CORRESPONDENCE FORMAppeal No: ABP -310466-21

ABP Ref: ABP-310466-21

Further Development of a Quarry**Application under Section 37L of the Planning and Development Act 2000, as amended.****Laurence Behan, Windmill Hill, Rathcoole, Co. Dublin**

WEST EXTENSION: Cross Section A:A' - North South

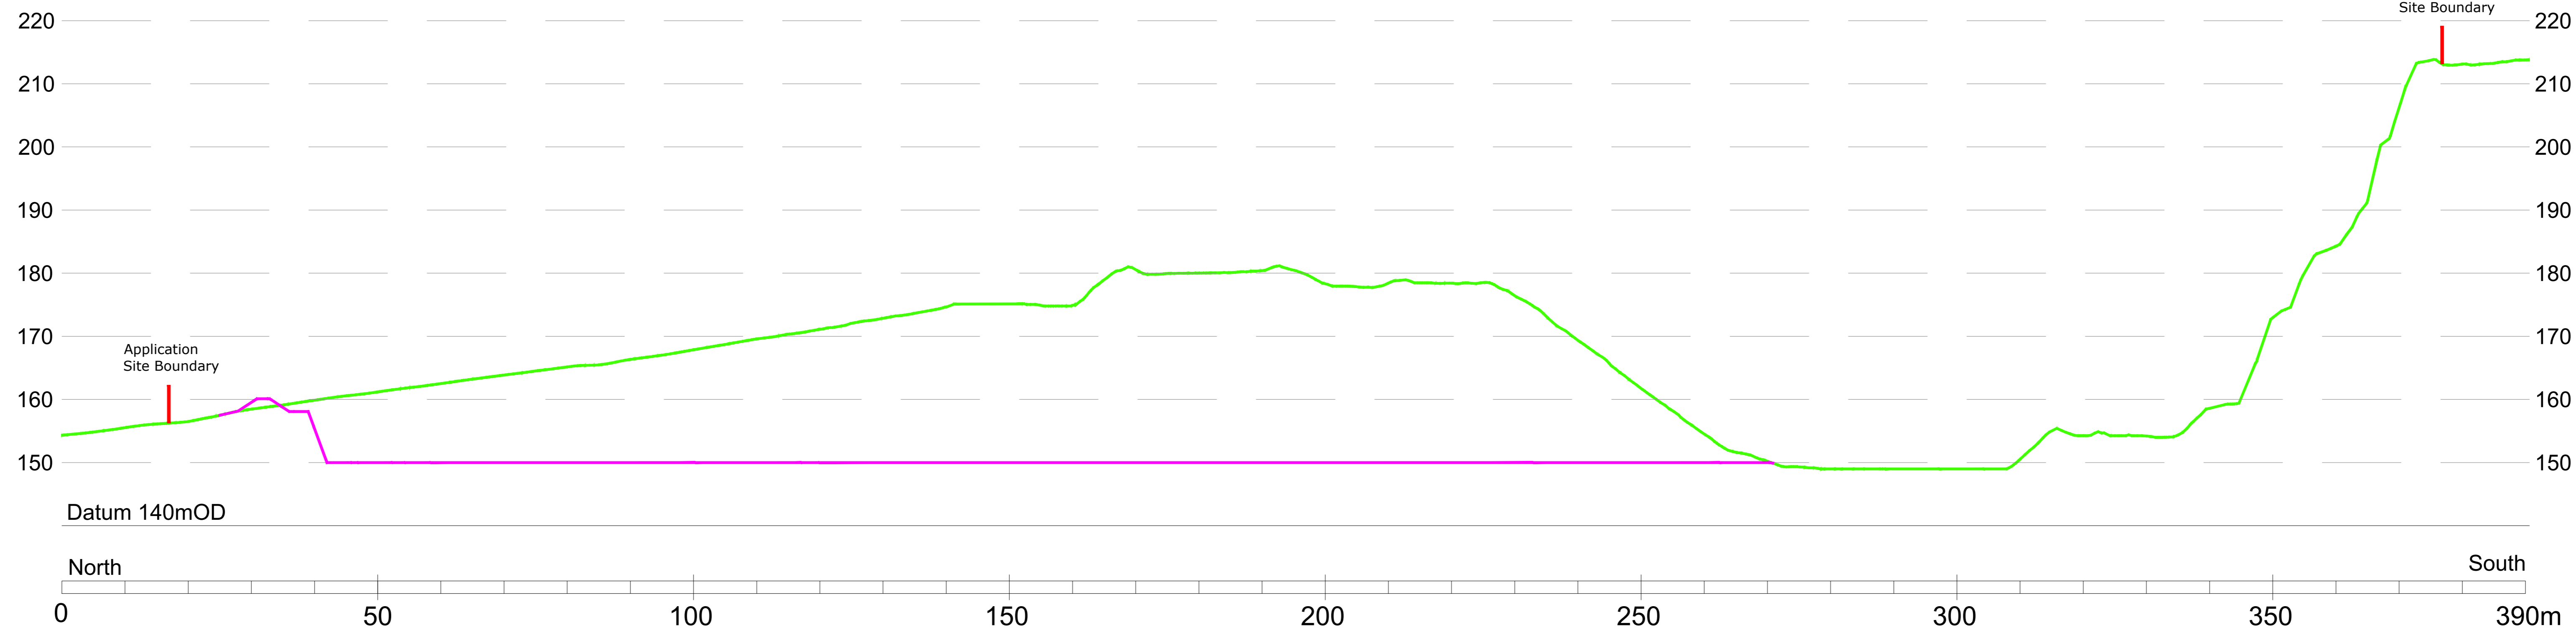
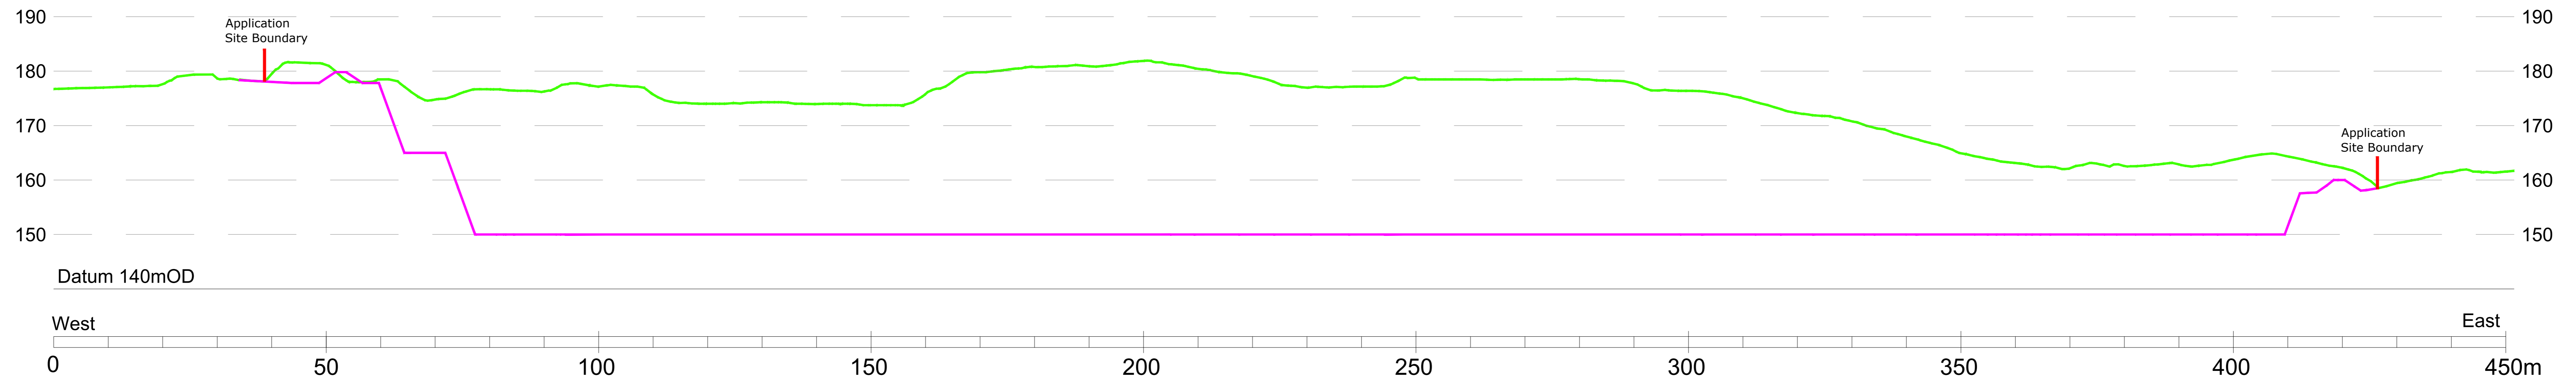
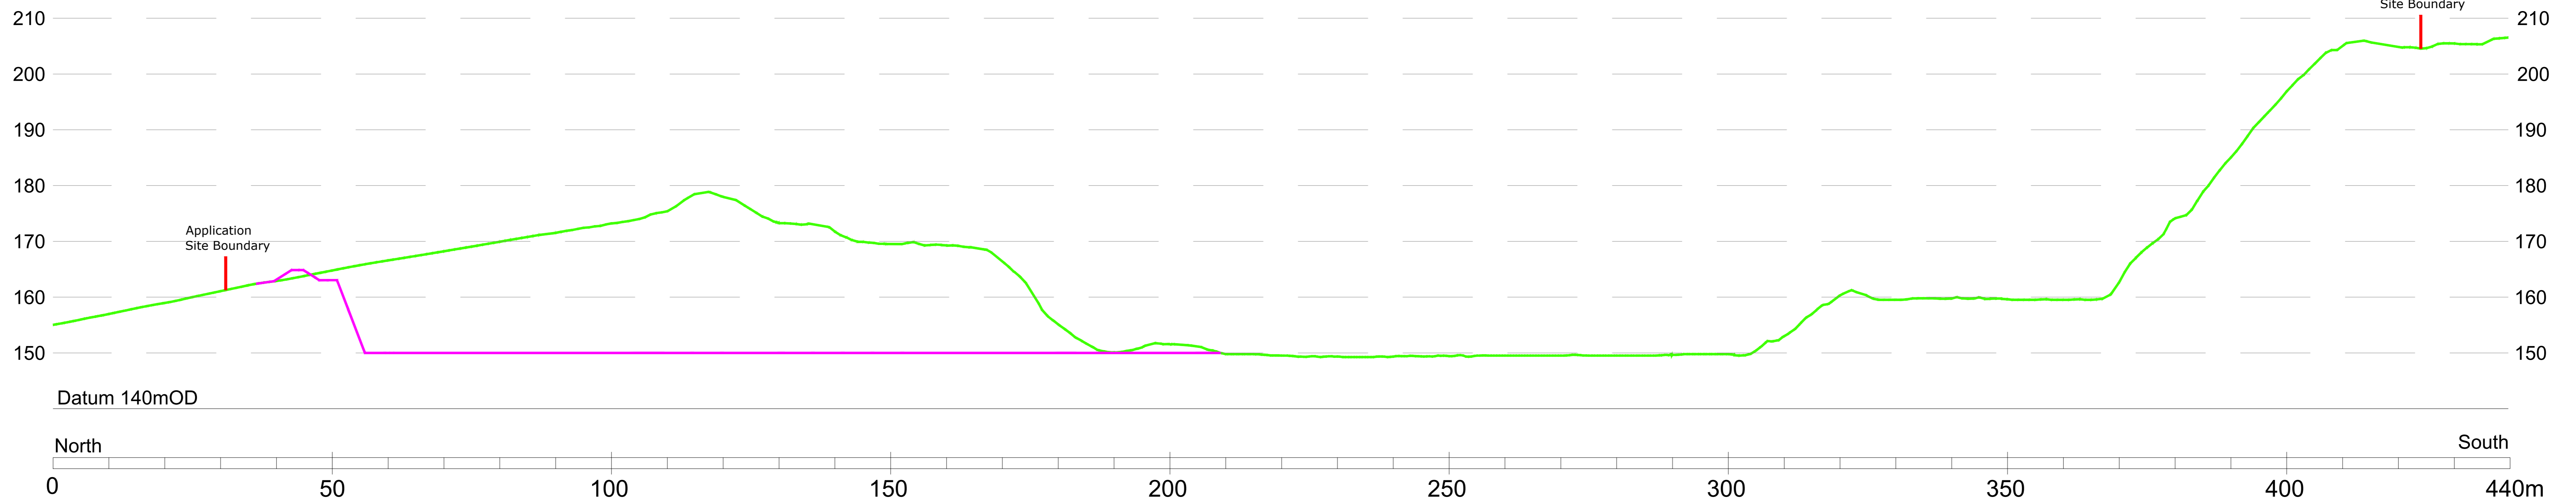
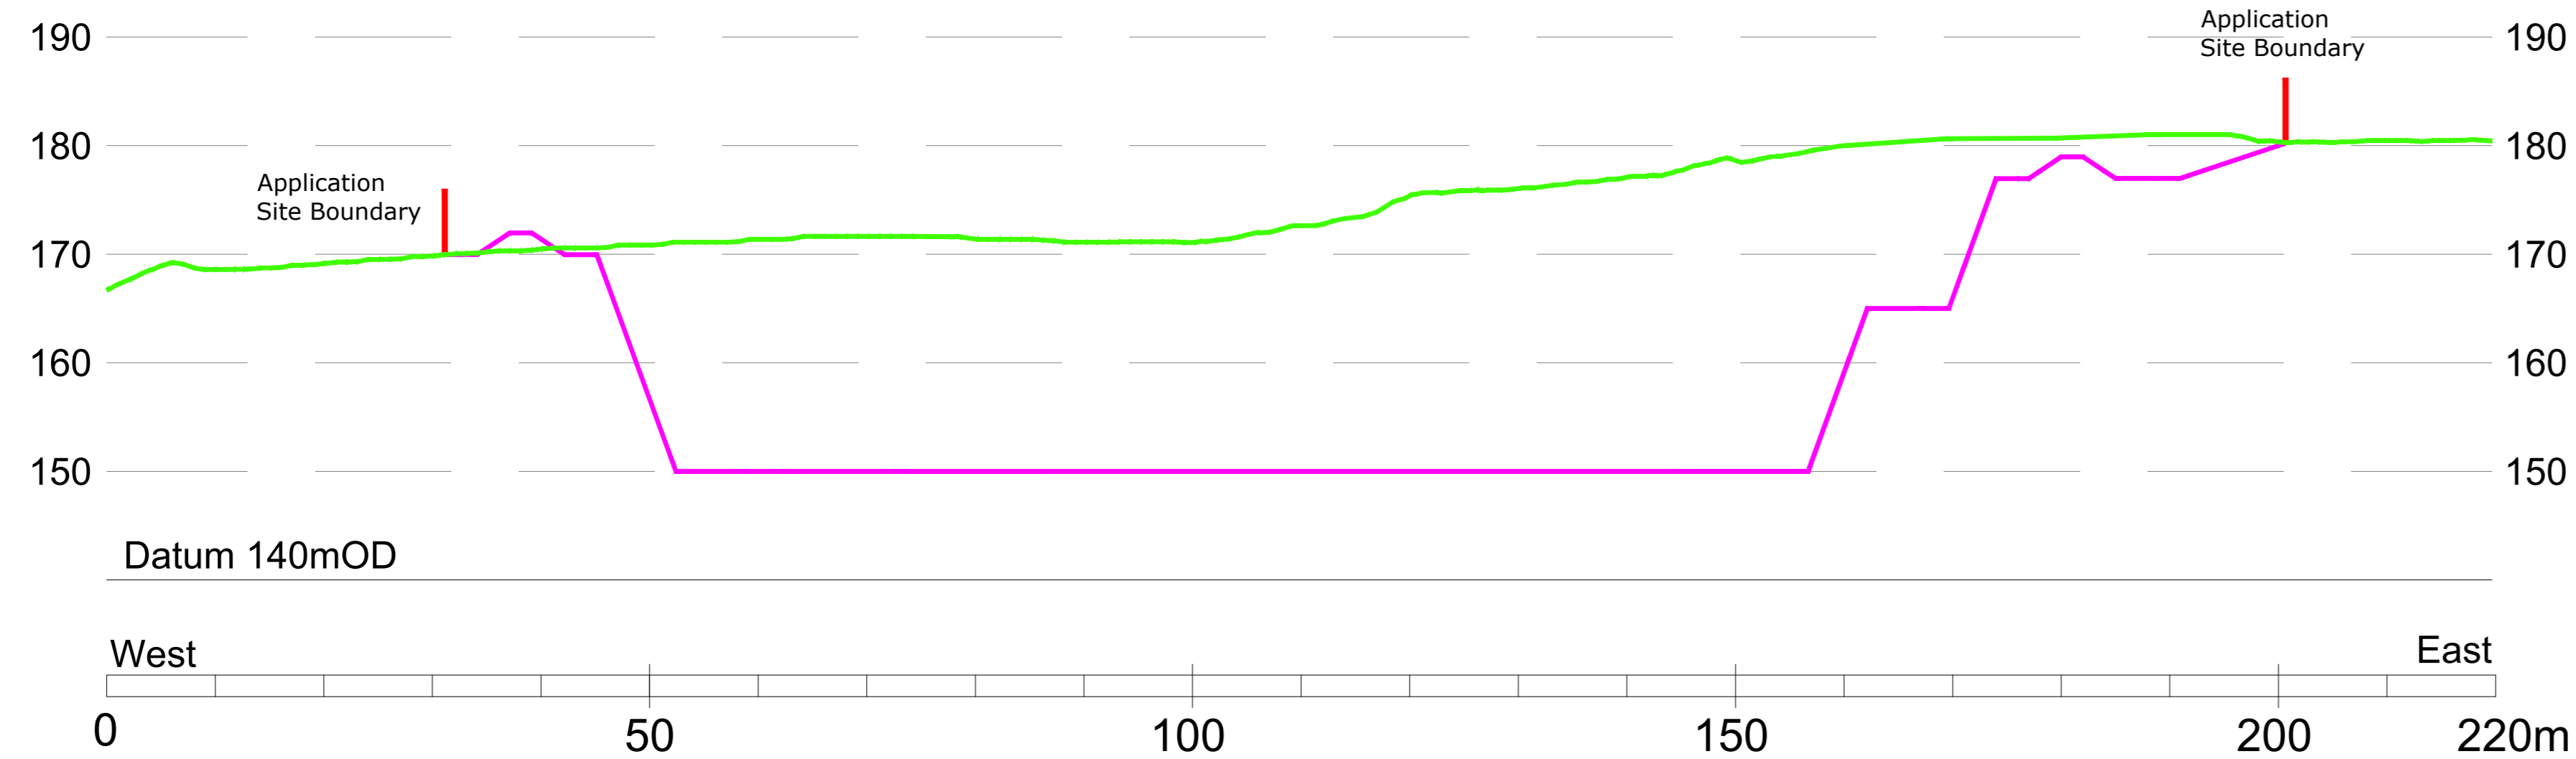
Item 5.2.4: This application relates to the continued extraction of reserves over a lateral extension of approximately 4.1 hectares and to a final average working depth of 150 mAOD (metres above Ordnance Datum). The Planning Authority notes that the current average working depth of the quarry is stated to be 173 mAOD (Section 2.1 of EIAR). The Planning Authority understands and reads that the proposed works, working to a depth of 150 mAOD, will take place outside of the existing quarry footprint. However, clarity should be sought on this matter and the applicant should state and demonstrate clearly the full extent of the proposed works in drawing and cross-sections which are unequivocal in nature, and which can be easily assessed over time.

Due to the extent of the site and the variation in working depth that can exist across benches and working areas, the development description provided 'a current average working depth of approximately 173 mAOD'. It was identified from topological survey data that extraction was by two benches, to an average depth of 173 mAOD, across the two benches.

An unequivocal final floor level has also been provided in the development description. The final floor level was identified as 'approximately 150 mAOD', (it should be noted that the use of 'approximately' or 'circa' is routine language in identifying quarry finished/final floor levels given coarse blasting/mobile plant extraction methods).
